Able Marine Energy Park

Material Change 2

Statement of Common Ground

ENVIRONMENT AGENCY

Figure 8-10: Predicted significant wave height for the selected offshore condition, MHWS, existing present-day bathymetry (GoogleEarth imagery)

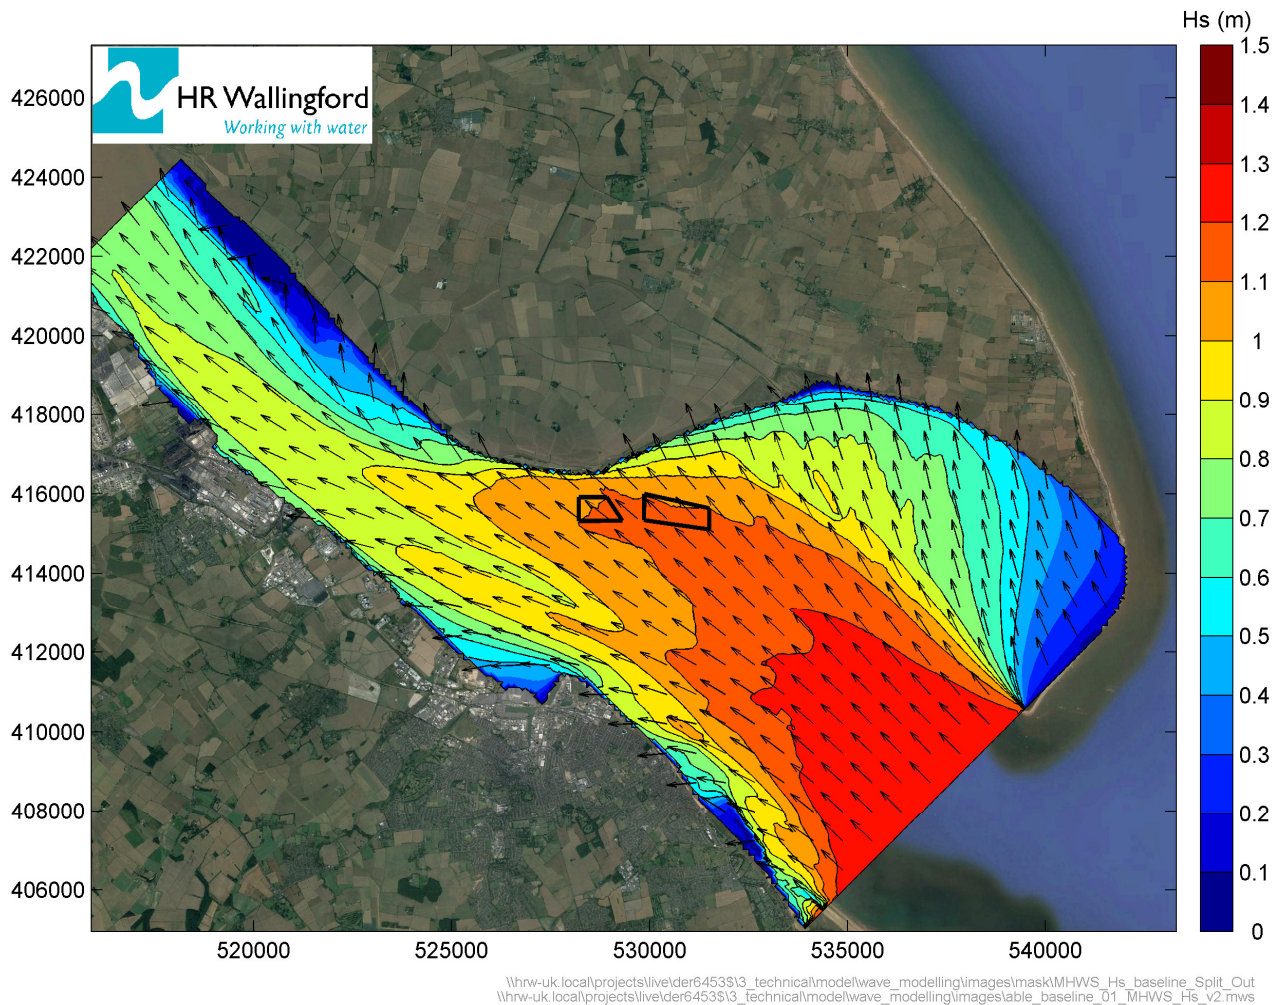
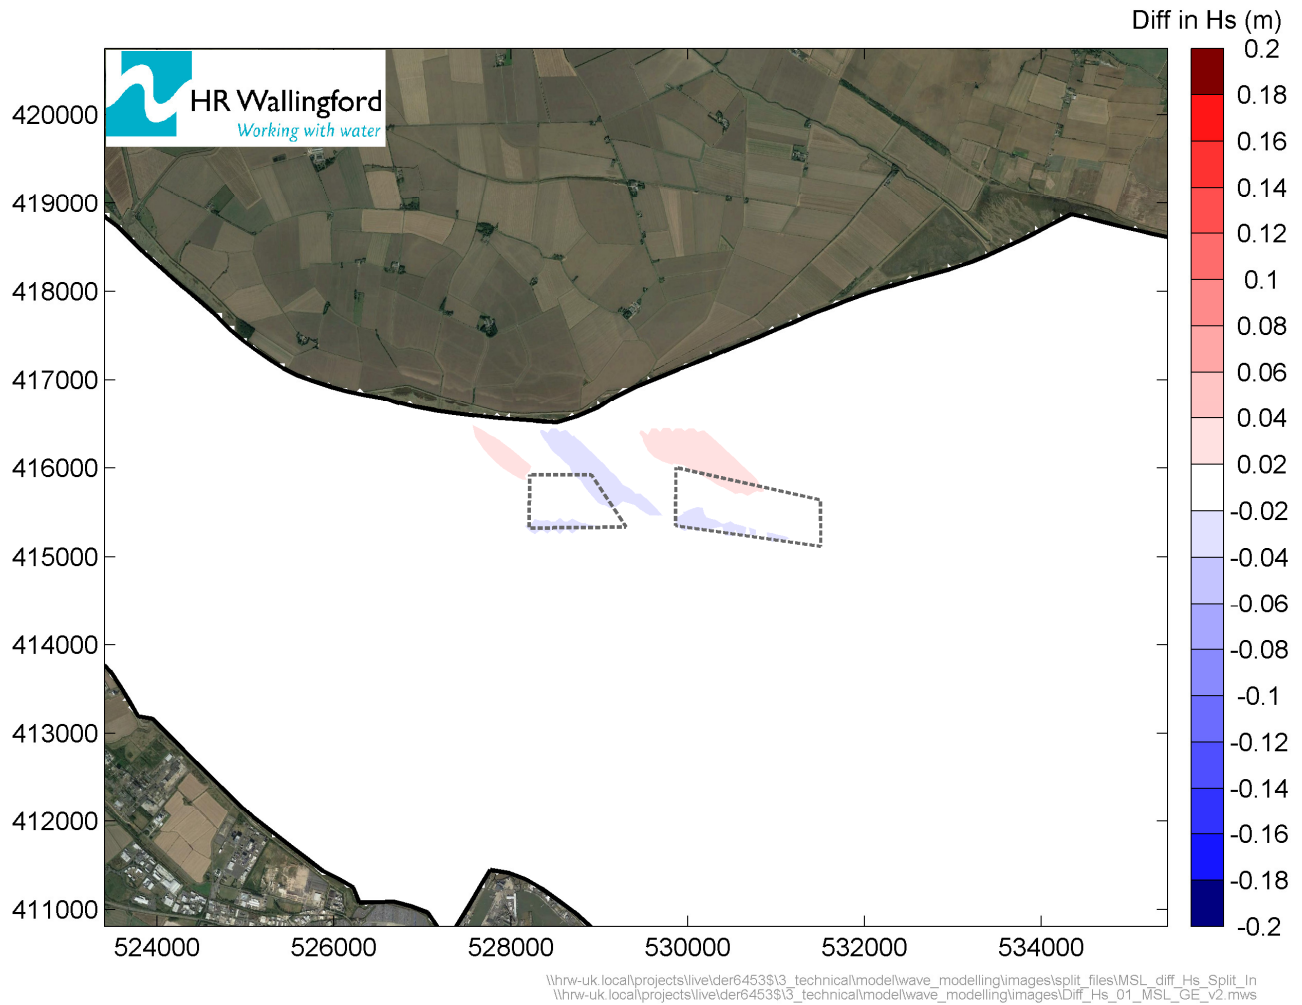
3.3 In its relevant representation, the Environment Agency noted that one wave condition was chosen to carry out this assessment, and requested more clarity as to why this particular condition, and only one, was chosen. The Applicant has attached to this SoCG at Appendix 1 a Schedule of Responses that includes an explanation for the particular wave condition used in the assessment.

<p>Environment Agency</p>	<p>4.1</p>	<p>Impact of changes to hydrodynamics on Hawkins Point (Section 8.4.36 onwards):</p> <p>One wave condition was chosen to carry out this assessment, but it is not clear why this particular condition, and only one, was chosen. We, therefore, request more clarity on this in order to provide confidence in the conclusions reached.</p>	<p>8.4.36 onwards</p>	<p>The nearshore wave rose for Hawkins Point (from The Humber Tidal Database and Joint Probability Analysis of Large Waves and High Water Levels Annex II, ABPmer (2007) report for the Environment Agency) is shown below.</p>  <p>Wave rose for Hawkins Point</p> <p>HR Wallingford</p>
---------------------------	------------	---	-----------------------	--

Selected wave condition is the same as was selected in EXB.7A
Hs 1m, Tm-10 4s, Dir 135 degrees - MSL, MHWS, MLWS
60% of all wave energy is incident from 110 to 150 degrees
99.7% of wave energy for waves of Hs = 1m or higher is from 110

In line with the original ES submission, to assess the potential changes to waves resulting from disposal activities (now at both HU081 and HU082), waves entering through the mouth of the estuary were selected. The value selected was Hs 1m, Tm-10 = 4s, and direction 135 degrees was considered appropriate to capture the effects on larger waves (which will “feel” the seabed at deeper depths than smaller waves) of the disposal mounds. In terms of why other directions were not selected, it is seen from the table and wave rose above that a) 60% of all wave energy (including much smaller waves) is predicted to be incident from between 110 and 150 degrees, and b) almost all waves of Hs = 1m and above are incident from this direction.

This single wave direction of 135 degrees was therefore representative of these incident waves. Importantly, the waves were also modelled for three different water depths (as per the original ES). For these larger Hs = 1m waves from 135 degrees, the predicted changes to wave height are negligible for MHWS, approximately +/-2cm for MSL, and approximately +/-5cm for MLWS.

Figure 8-14: Google earth Imagery of Hawkins Point (2007 and 2019)

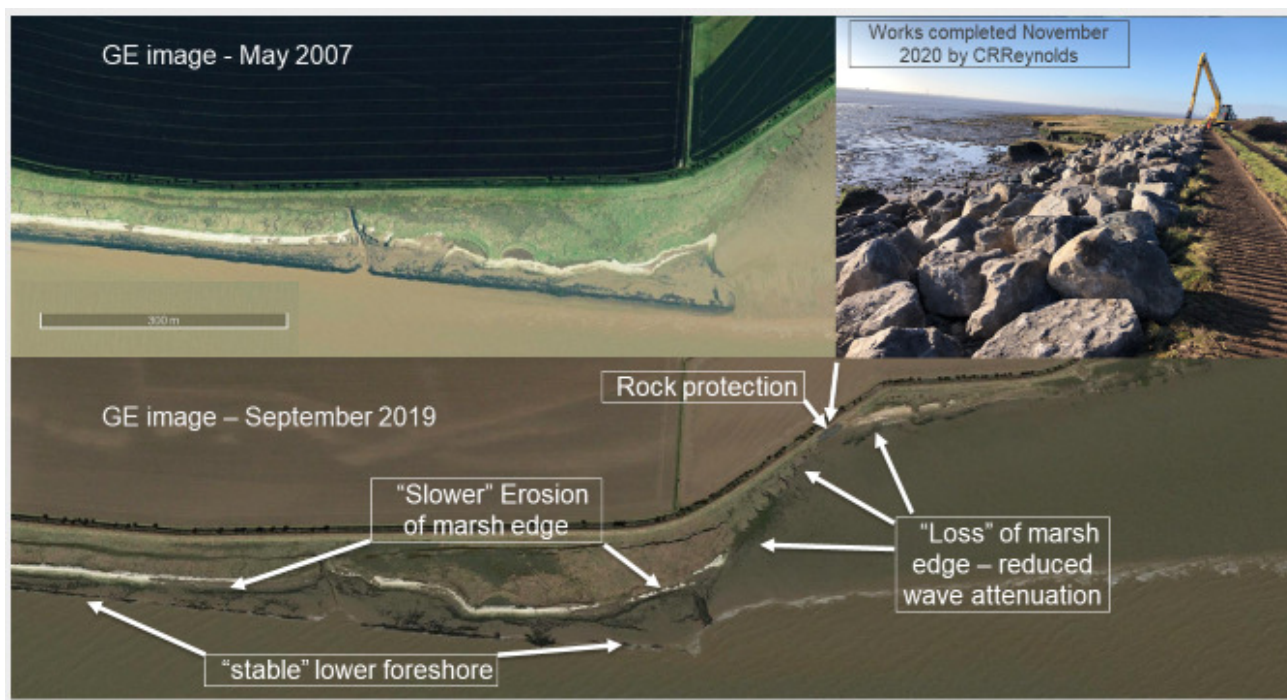
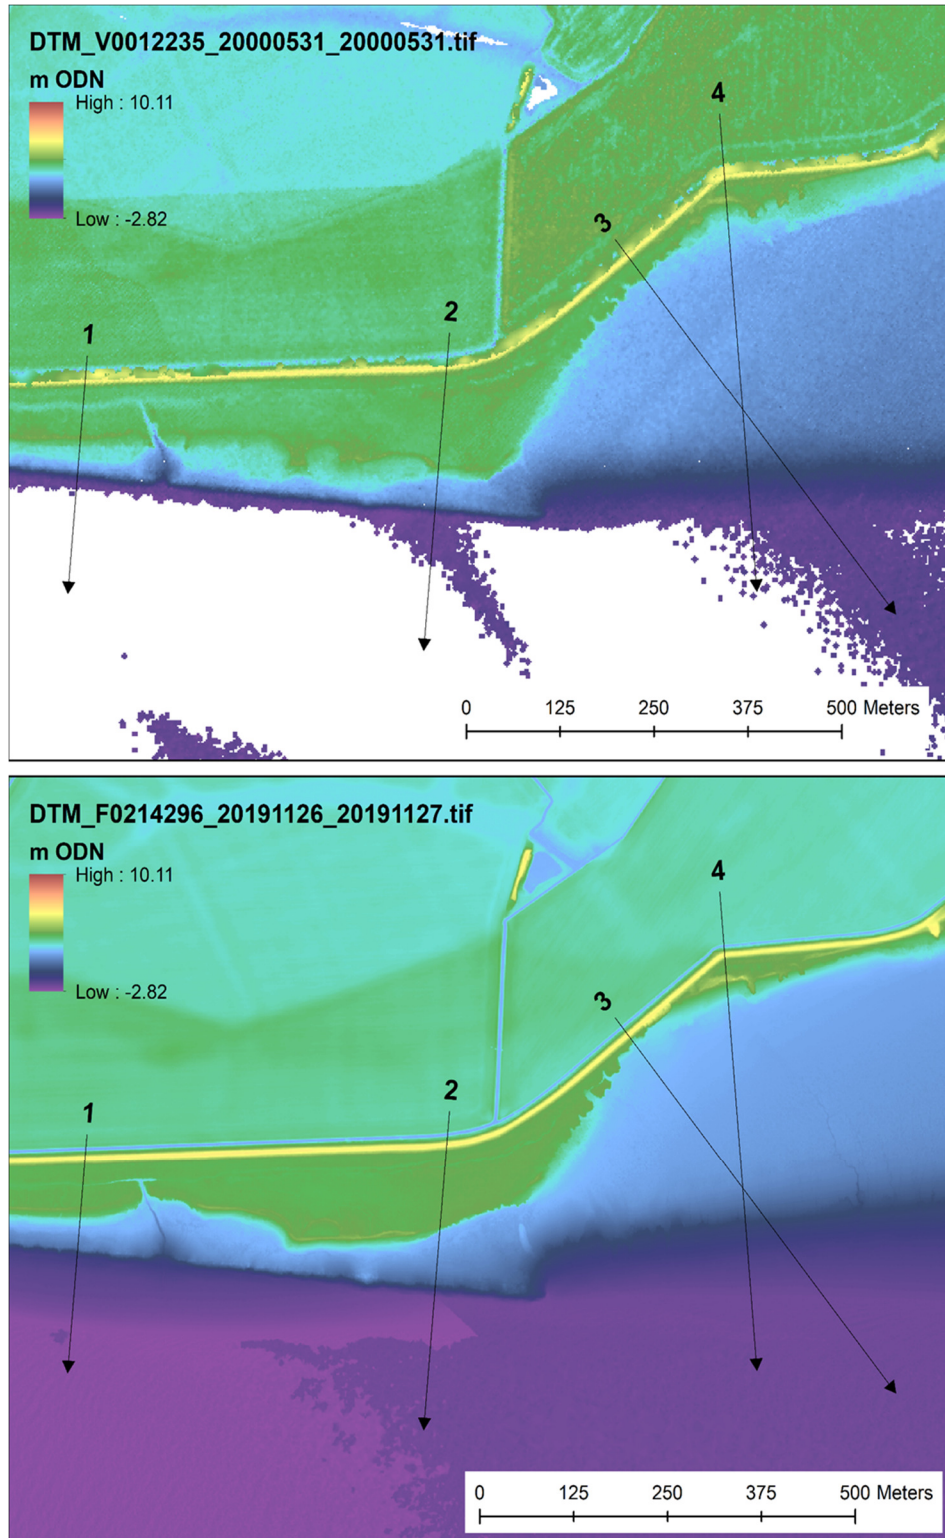
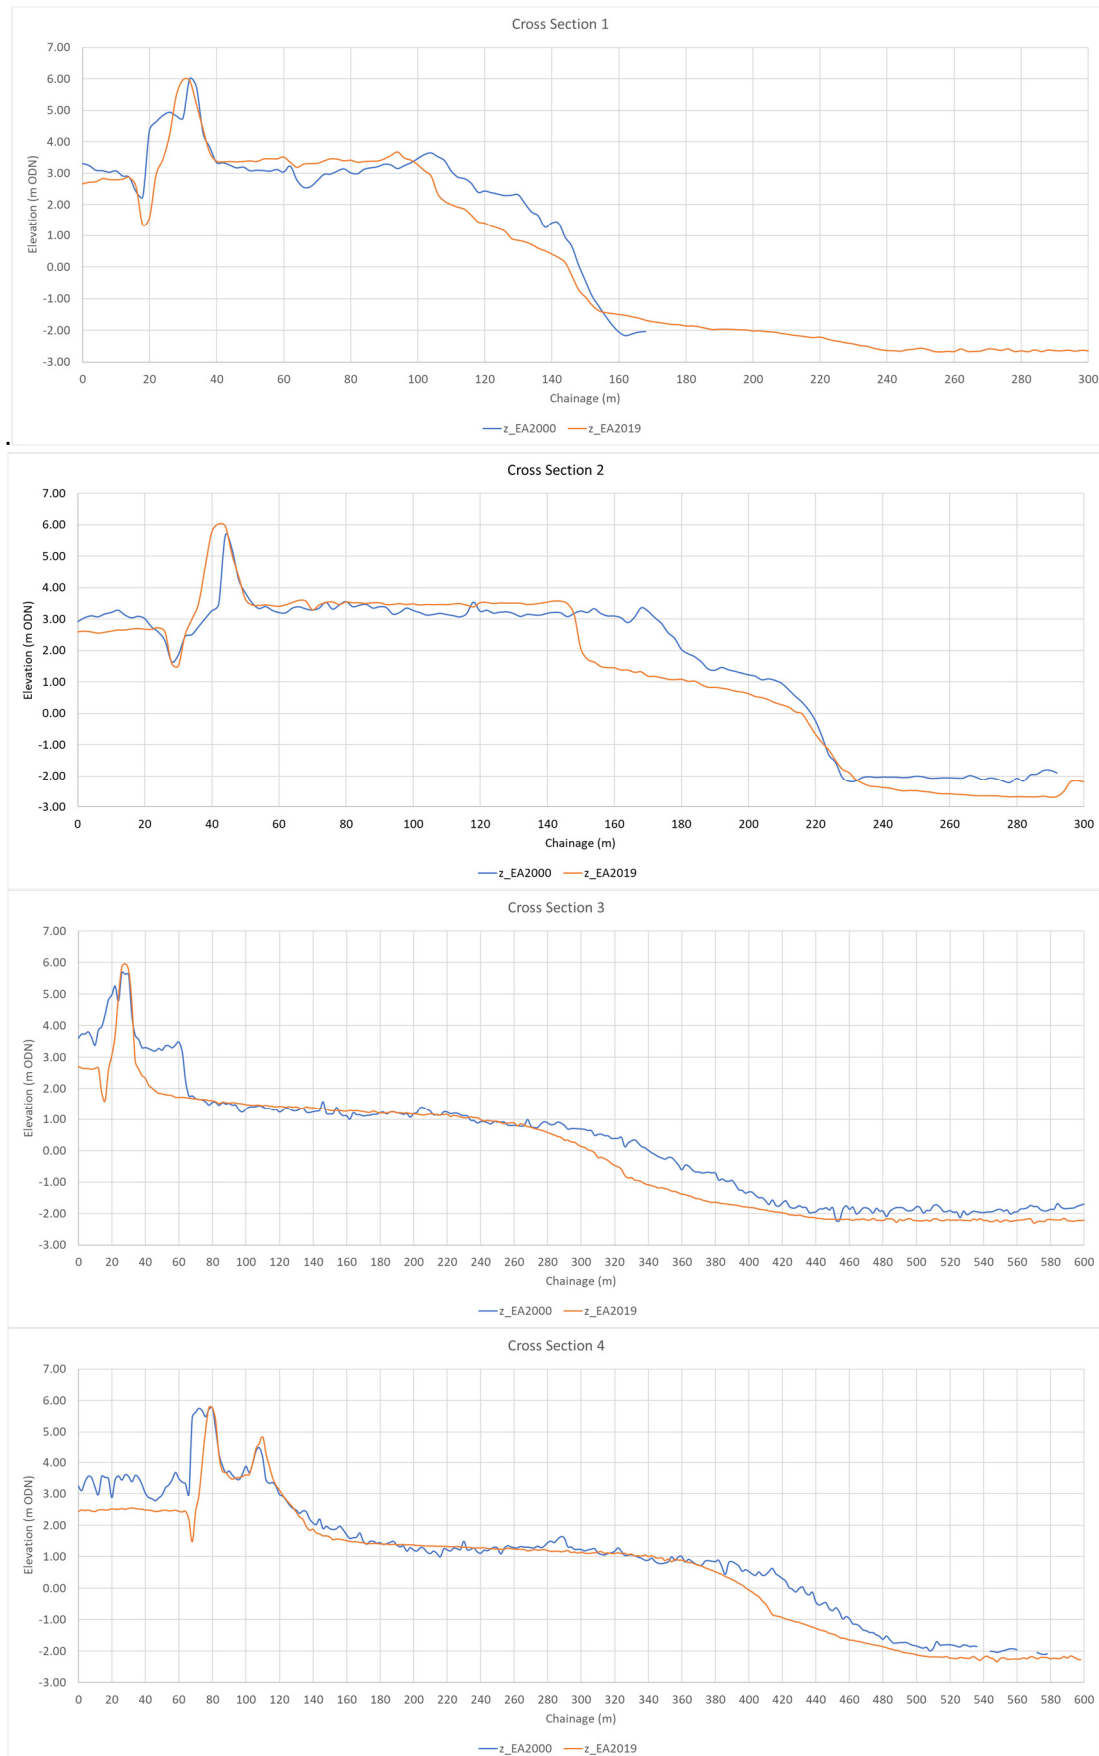
- 3.8 The Environment Agency requested in its relevant representation that potential impacts from increased wave activity resulting in foreshore erosion to the west of Hawkins Point needed some further consideration in regards to risk to habitat/flood defences. The Applicant has attached to this SoCG at Appendix 1 a Schedule of Responses that includes an explanation of the impacts on the foreshore at Hawkins Point. The Environment Agency is content with the Applicant's assessment.

also indicate some increasing wave activity which could result in foreshore erosion to the west of Hawkins Point (8.4.39). Whilst this section of the foreshore is currently stable, the potential impact here needs some further consideration in regards to risk to habitat/flood defences.		<p>assumed to be filled to the -5.3mCD limit, when in reality it is expected that the post-construction level will be lower than this.</p> <p>The predicted changes to waves are within the natural variability of incident wave conditions The predicted changes are transient (they will diminish with the dispersion of disposed material from HU081 and HU082) and are expected to last for a few years.</p> <p>Overall, for the above reasons, there is considered to be no increase to flood risk.</p> <p>Analysis of historic change of profiles derived from LiDAR data running across the low intertidal up to the elevation of marsh level have shown that to the west of Hawkins Point the lower intertidal of the foreshore is relatively stable, unlike that to the east of Hawkins Point. Whilst it is recognised that at MLWS and MSL there are small increases in wave heights (see above) it is not considered that such small increases will lead to significant erosion of the lower foreshore which appears currently to be stable. The increases are likely to be insignificant within the natural variability of the incident wave conditions.</p> <p>If this foreshore were presently subject to erosion a small increase in such erosion might be anticipated for the few years that it will take for the glacial clay to disperse from the disposal sites. However, given the relative stability of the lower foreshore to the west of Hawkins Point, it is unlikely that the small predicted increase in wave height at lower water levels will be sufficient to instigate a trend for erosion.</p>

Figure 8-23: Modelled changes to peak mean spring tide ebb flows (AMEP Amended Quay layout minus updated baseline).

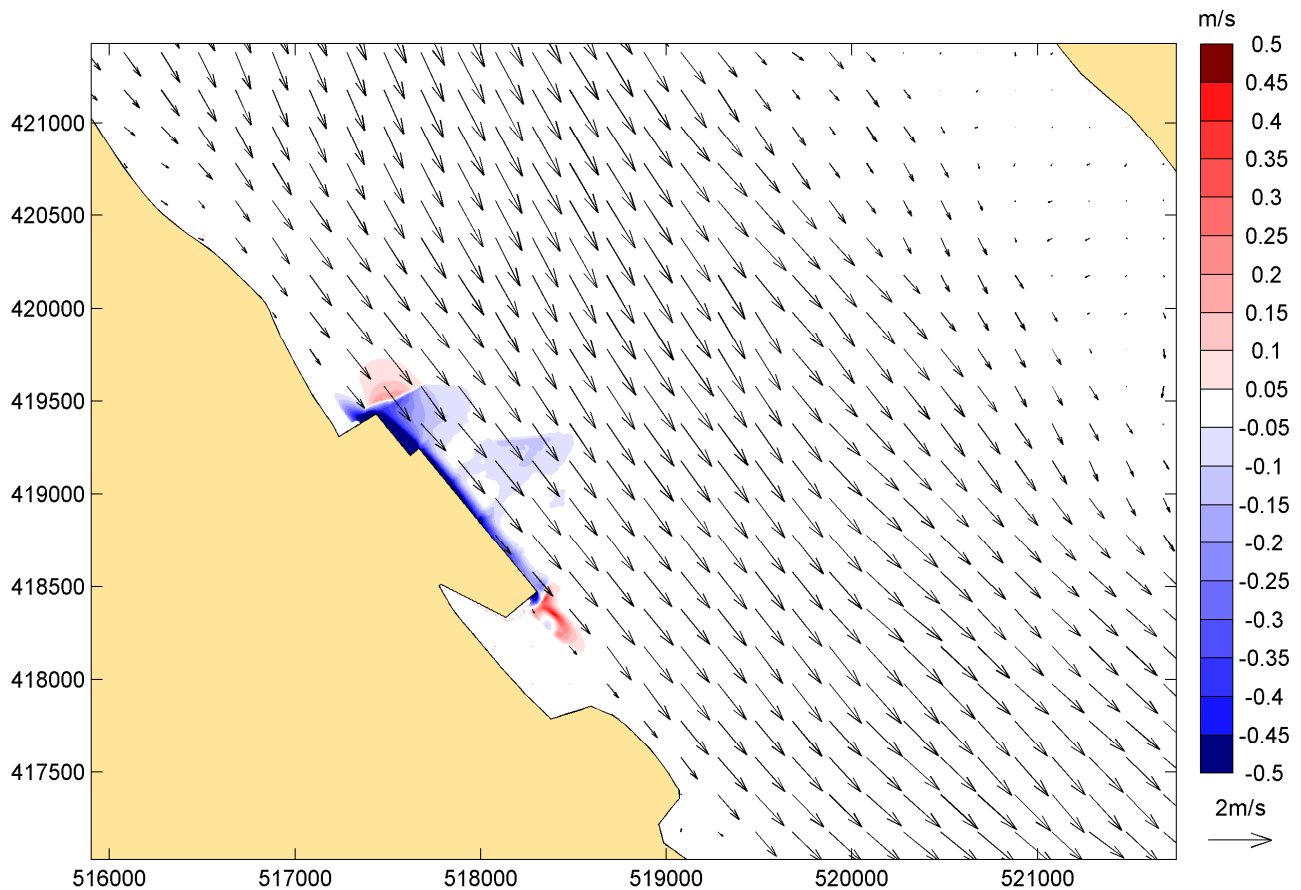
- 3.11 In its relevant representation the Environment Agency stated that to safeguard any consequences from the potential flow acceleration during the ebb tide off the downstream end of the quay, the additional mitigation set out in section 8.5.2 of the UES must be secured using an appropriate mechanism. It also requested that monitoring be undertaken for a minimum of 10 years, and that the Applicant should set out what remedial action will be taken if impacts arise. This will be secured via the Marine Environmental Management and Monitoring Plan that the MMO must approve pursuant to the DCO.

4.6	<p>To safeguard any consequences from the potential flow acceleration during the ebb tide off the downstream end of the quay, we require the additional mitigation set out in 8.5.2 to be undertaken, and included/secured using the appropriate mechanism (e.g. Marine Licence, Marine Environmental Management and Monitoring Plan etc, or monitoring legal agreement with the Agency). Currently there is no time limit specified in 8.5.2 for monitoring aspects - we require this to be for a minimum of 10 years. We also request that the applicant indicates what remedial action they will implement if this risk is realised.</p>		<p>The flow acceleration for the amended quay on the ebb tide is predicted to occur slightly further inshore and over a smaller area than was the case for the consented quay. The increased ebb tide currents are in line with the AMEP quay and extend downstream for up to 500m on spring tides. Peak speeds on the ebb tide at South Killingholme Oil Jetty may increase by up to 0.3m/s and at the Immingham Gas Jetty by up to 0.1m/s.</p> <p>It is not expected that mitigation will be required for this effect.</p> <p>A proposed monitoring schedule is provided below to supplement the information in Section 8.5.2.</p> <p>The monitoring includes for pre-construction activity, monitoring and compliance reporting during the dredging and continued monitoring post-construction. It is proposed that the post-construction monitoring be reviewed 3 years after disposal activities at HU081/82 is completed.</p> <p>Current measurements in proximity to South Killingholme Oil Jetty will be made pre- and post- construction of AMEP on spring tides of a similar range.</p>

- 3.12 The flow acceleration for the amended quay on the ebb tide is predicted to occur slightly further inshore and over a smaller area than was the case for the consented quay. The increased ebb tide currents are in line with the AMEP quay and extend downstream for up to 500m on spring tides. Peak speeds on the ebb tide at South Killingholme Oil Jetty may increase by up to 0.3m/s

- SoCG - Environment Agency ([draft 1.2.22](#))[final 15.2.22](#)-signed 7
- and at the Immingham Gas Jetty by up to 0.1m/s. The parties agree that it is reasonable to expect that mitigation will not be required for this effect.
